Your Ref: ACP-324601-26

DAU Ref: 85/86 Mulkear View, Newport, Co. Tipperary

Re: Notification under Section 177(AE) of the Planning Development Act 2000 (as amended)

Proposed Development: a) The Demolition and removal of No.85 Mulkear View (footprint of 62m²), and the Construction of a ground floor side extension of 18m², for No.86 Mulkear View, in its place. b) There will be no drainage or service alterations required as all surface drainage, stormwater drainage and foul sewer drainage will connect to the existing infrastructure onsite. c) There will be no change in the site use or site capacity for existing drainage and wastewater infrastructure. d) Wastewater will continue to be treated at the local Newport WWTP. e) All earthworks will be contained within the site boundary. The development proposed partially encroaches into a Special Area of Conservation, namely SAC 002165 Lower River Shannon. A Natura Impact Statement has been prepared in respect of the proposed development at No.85/86 Mulkear View, Tullow, Newport, Co. Tipperary.

Figure 3.2 Plan of the proposed development¹⁴¹⁴ Source: Tipperary County Council - see accompanying drawing set for full scale version.

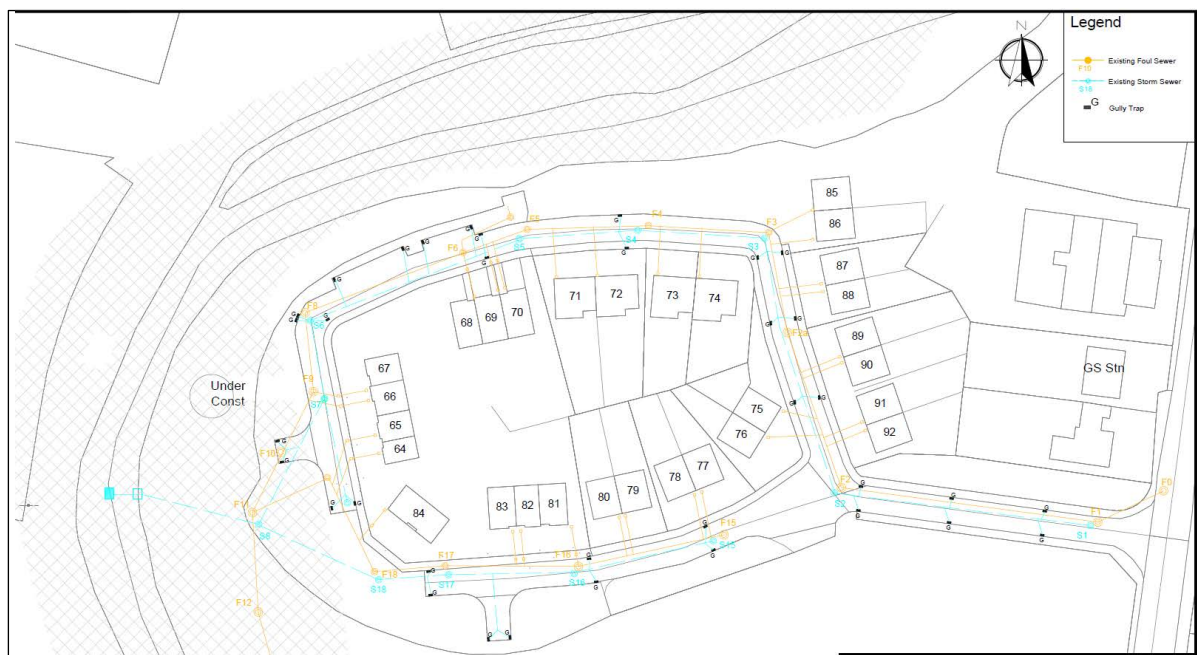
The proposed public link walkway (NIS Fig 3.2) is likely to lead to increased usage of this area, including at night, with consequent risk of disturbance to Otters (including when foraging). There is also the potential for lighting disturbance, if lighting is proposed. The potential impacts on the SAC from the inclusion of the walkway in the proposed development plan have not been addressed in the NIS.

The potential impacts on bat species using the riparian area from the proposed pedestrian link walkway will also need to be assessed, particularly in relation to any proposed vegetation

clearance or lighting. Any such assessment should include a comprehensive bat activity survey using static detectors, appropriately situated. It should be noted that the site is within the currently known range of Lesser Horseshoe Bats (Annex II) and it is crucial to maintain the availability and quality of the Mulkear River as a commuting corridor for Lesser Horseshoes and other bat species.
